**From:**  
**To:** [DCAdmin](#)  
**Subject:** Fwd: Planning Application 2022/90484  
**Date:** 18 March 2022 21:56:22

As a close neighbour to this applicant and the proposal, I wish to object strongly to its size and design. Due to the lack of dimensions on the submission, I have taken advice from a very experienced building consultant. He has calculated the floor area to be 68 sq.m. and the height to ridge, 7 m. In addition, the proposed site is elevated from the surrounding land and buildings which would increase the visual impact further, overshadowing a large area. Described as a "garage" it seems far too high and large for the proposed domestic use.

Drawing
Planning Scheme - Proposed Site Sections and Garage GA

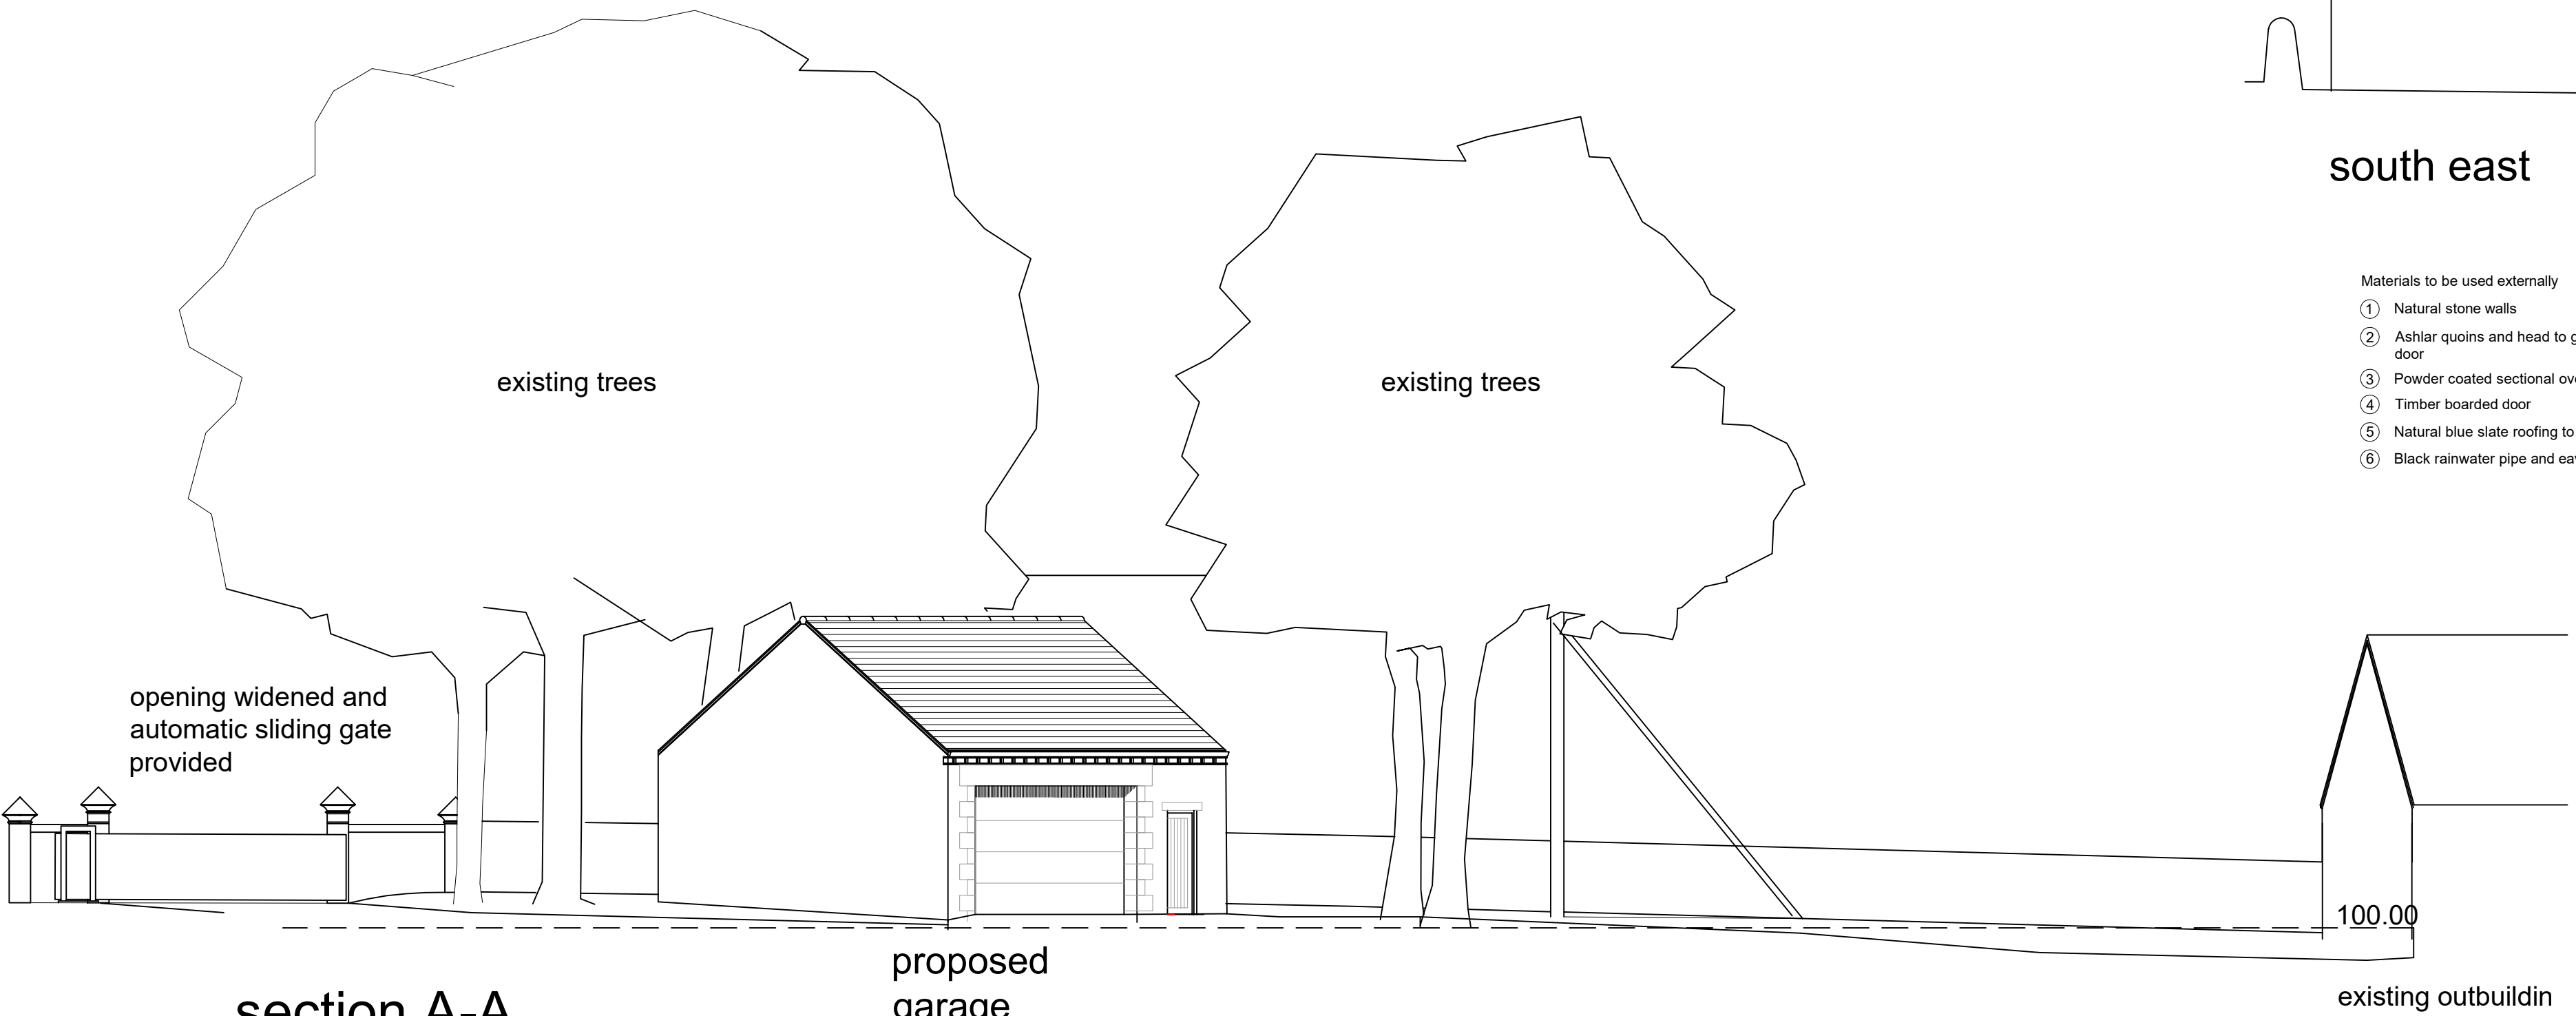
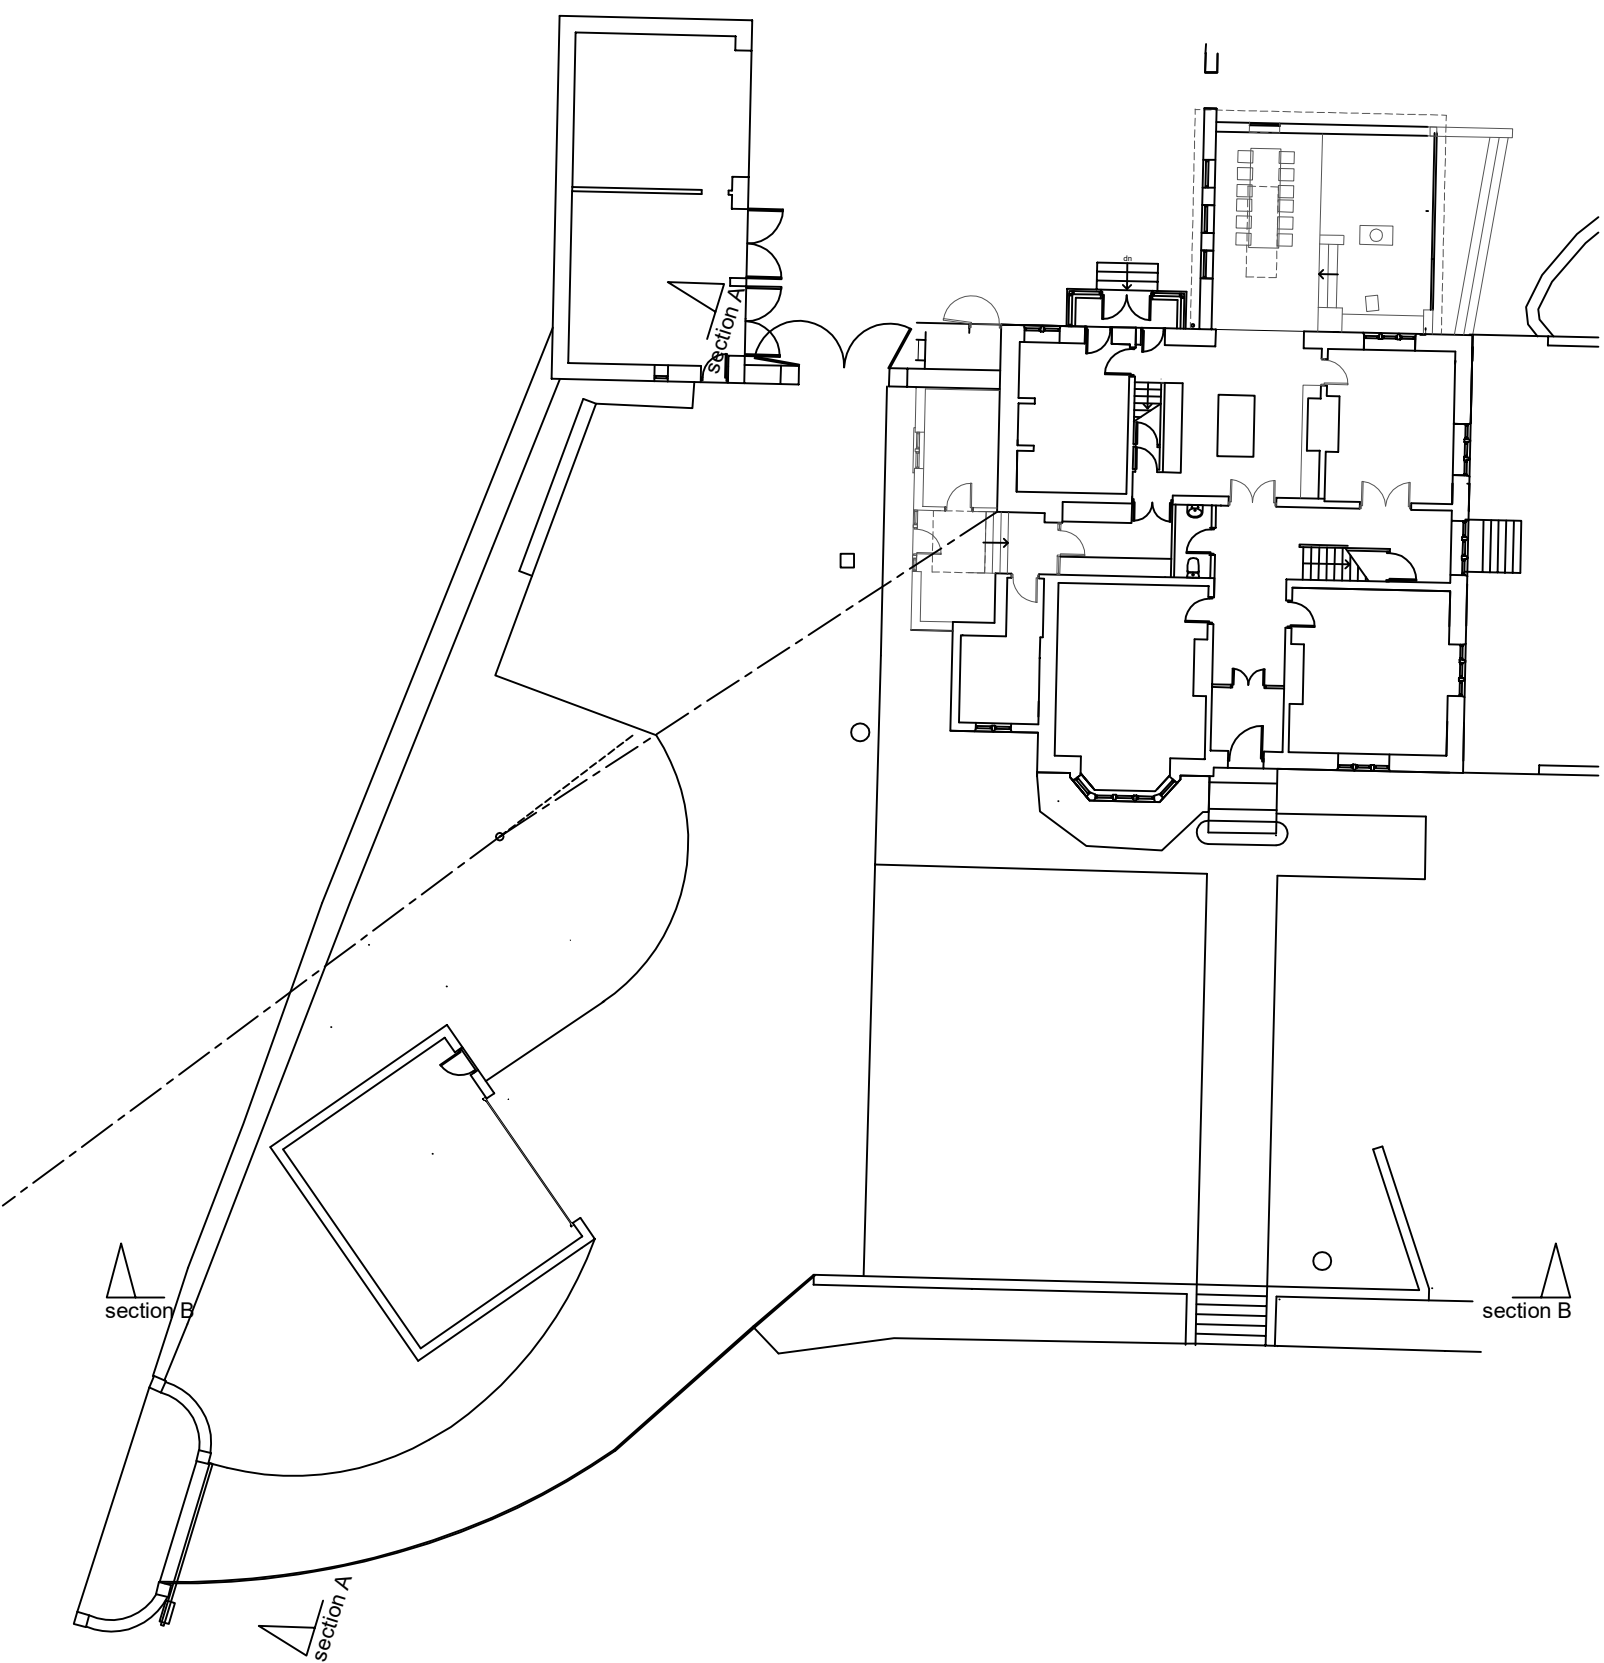
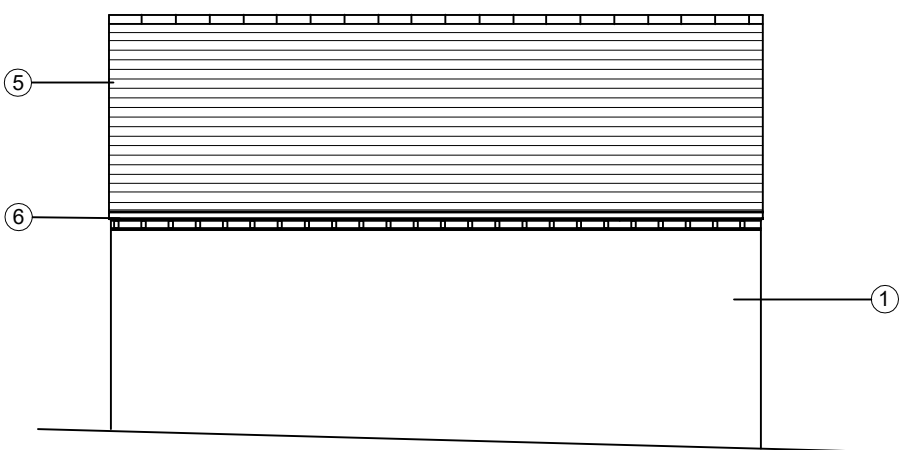
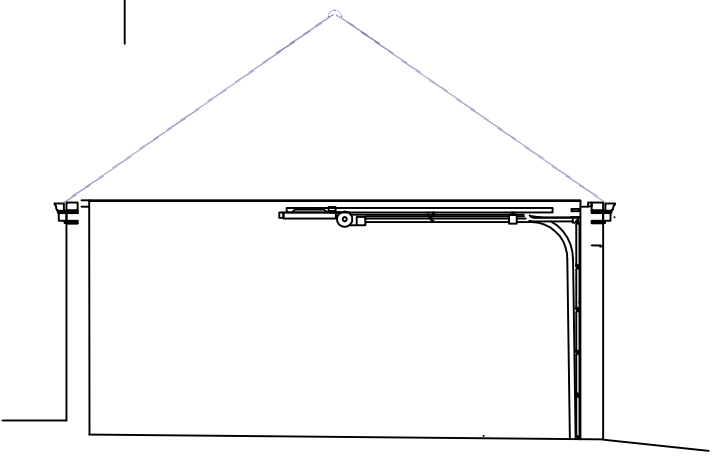
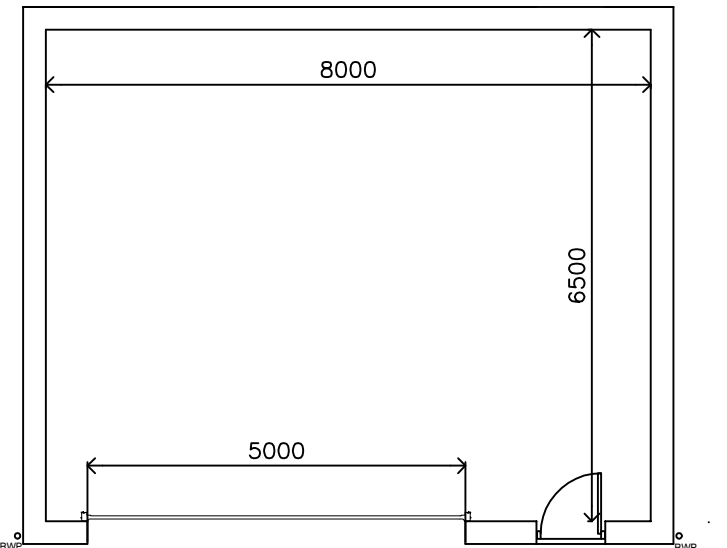
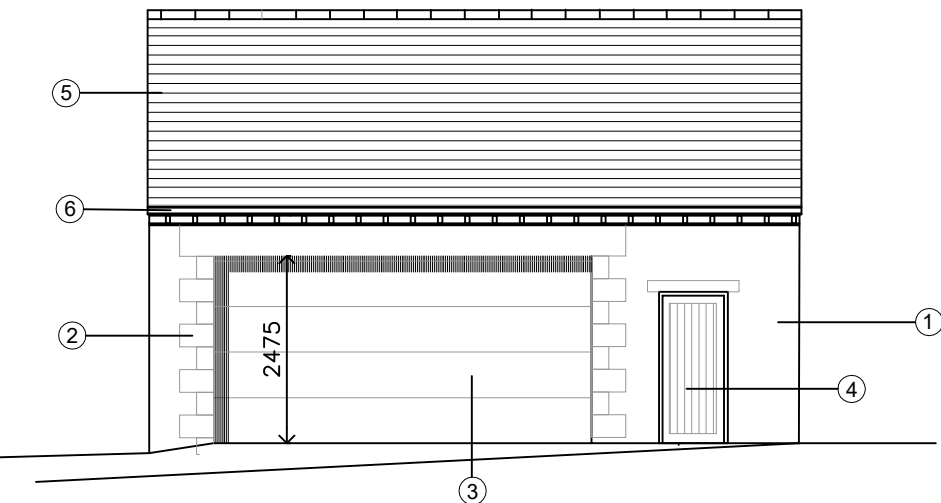
If built, it would be a massive, overbearing structure.

In short, this proposal would have the appearance of a very large warehouse.

Shepley Carr House : Proposed Layout

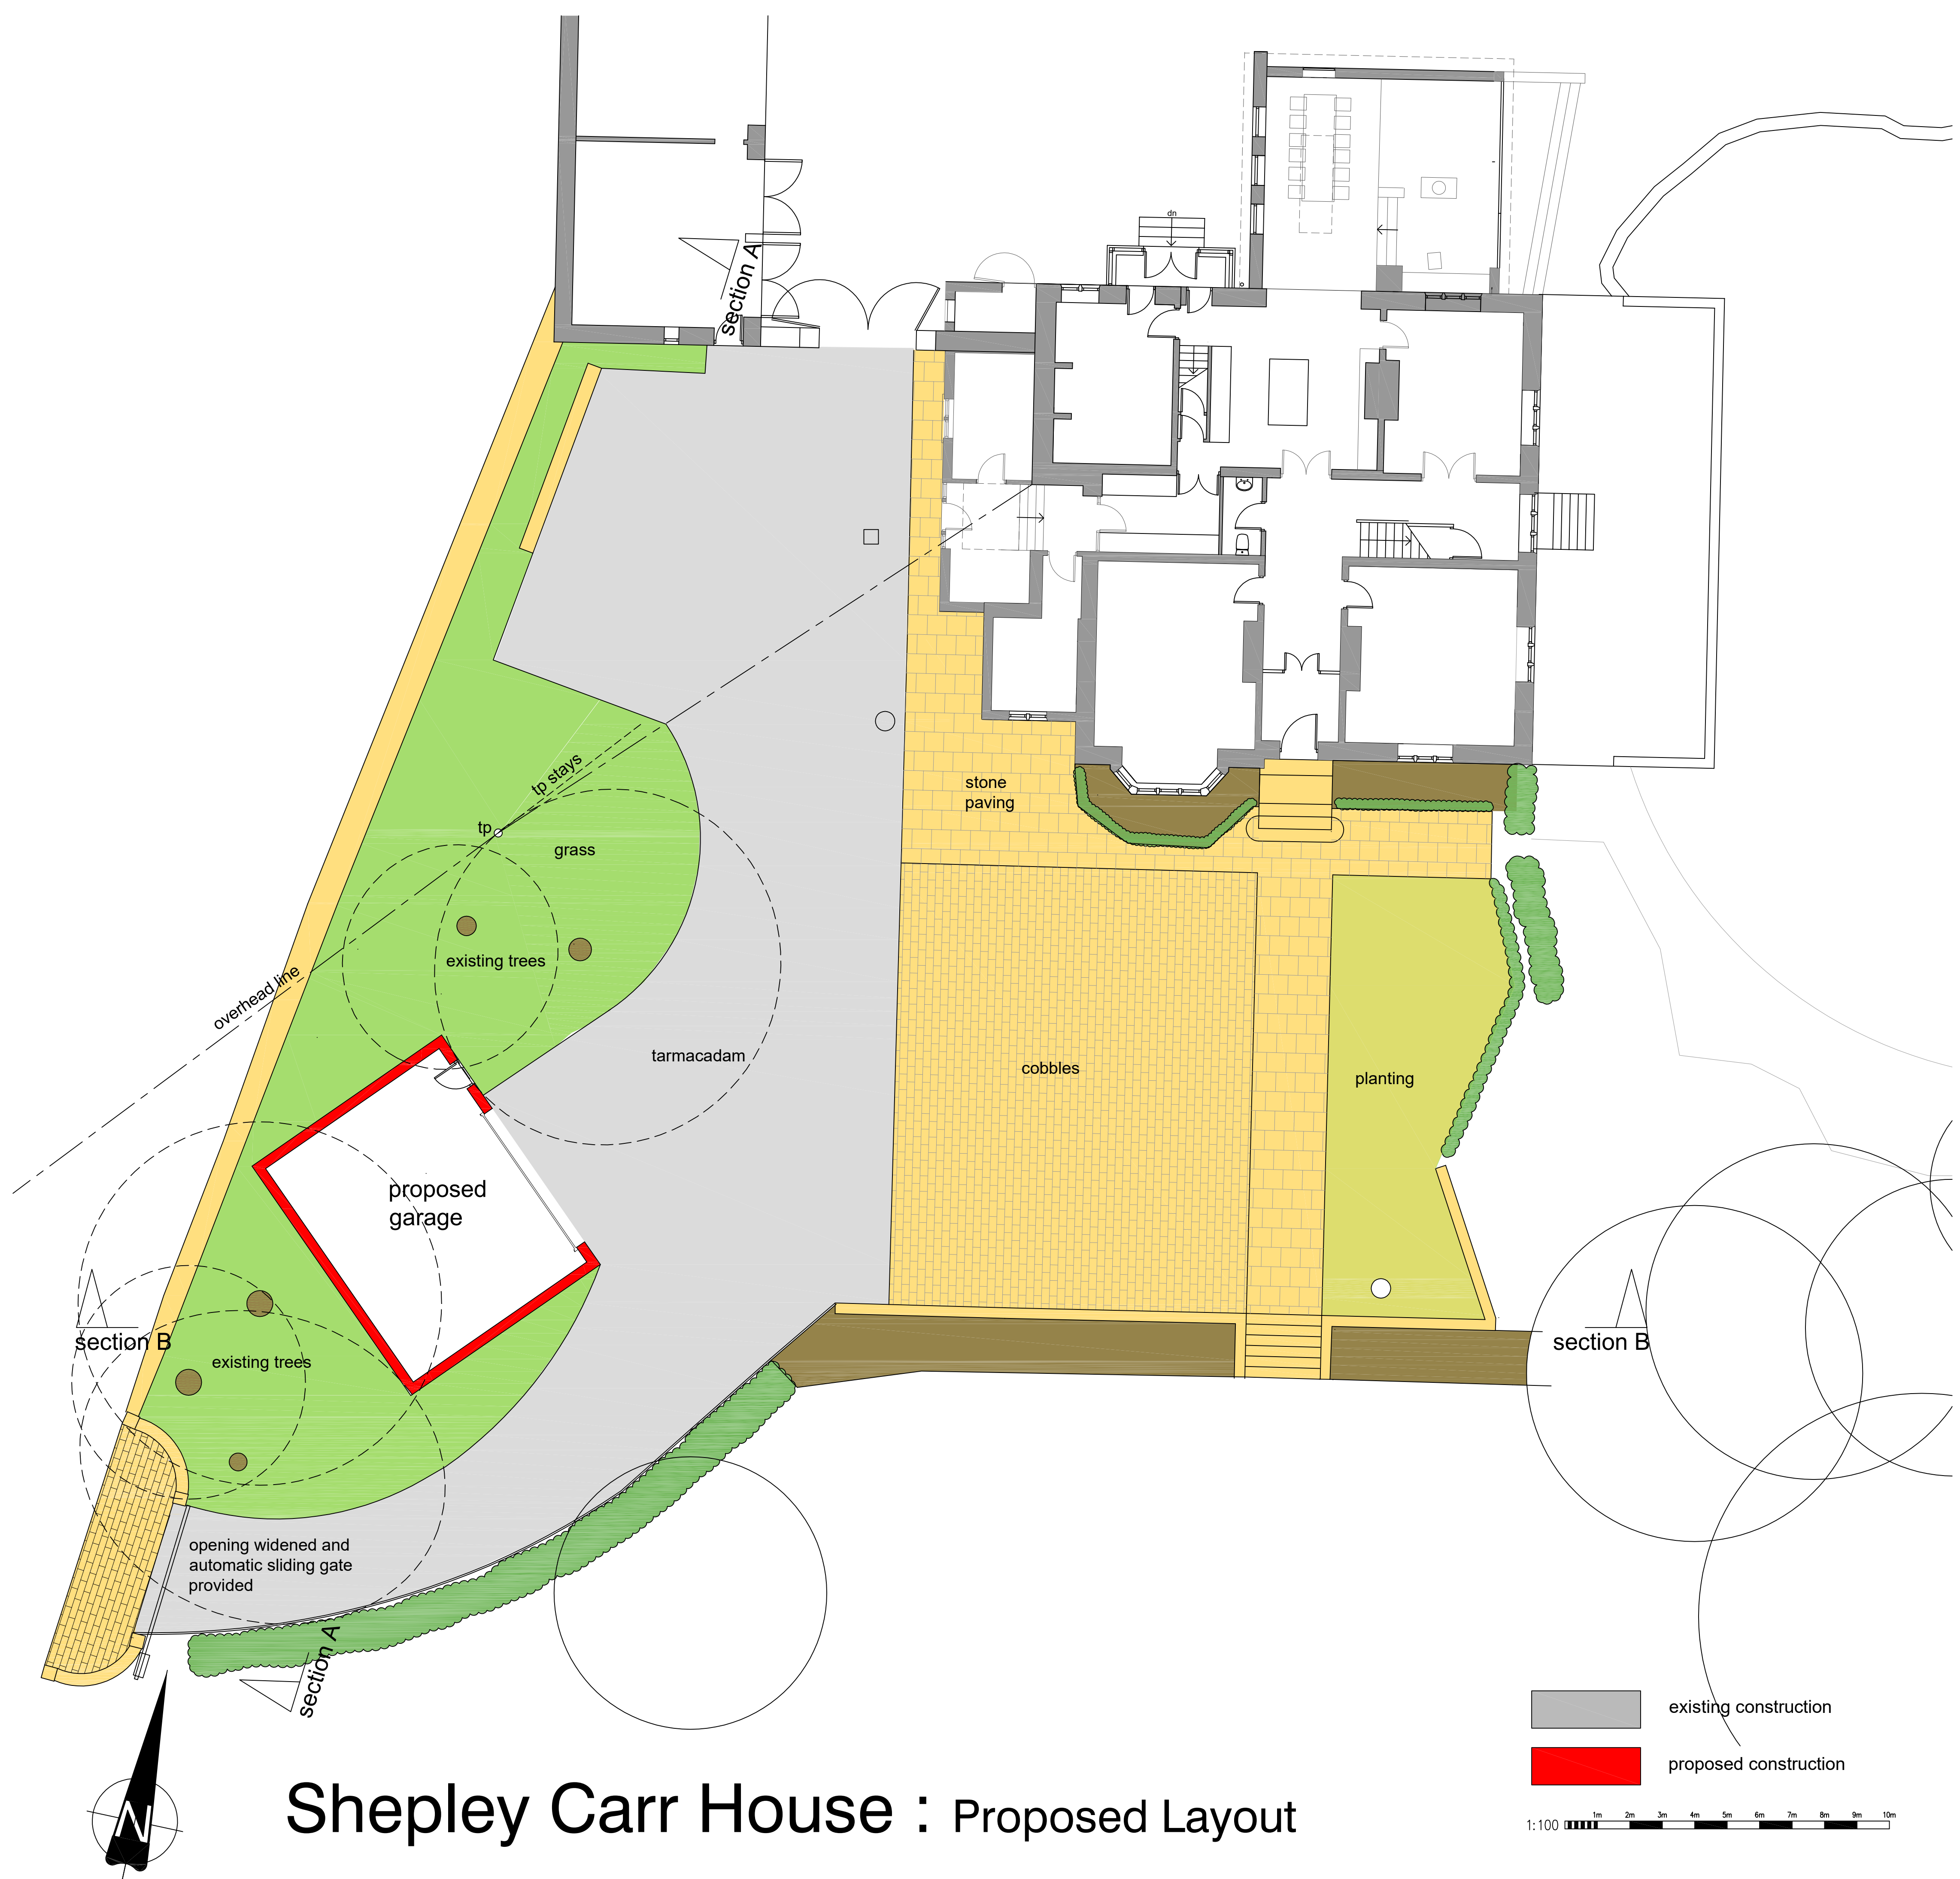
Furthermore, there are a number of mature trees on this site which would be obstructive. I cannot see how this building could proceed without destruction of these trees.
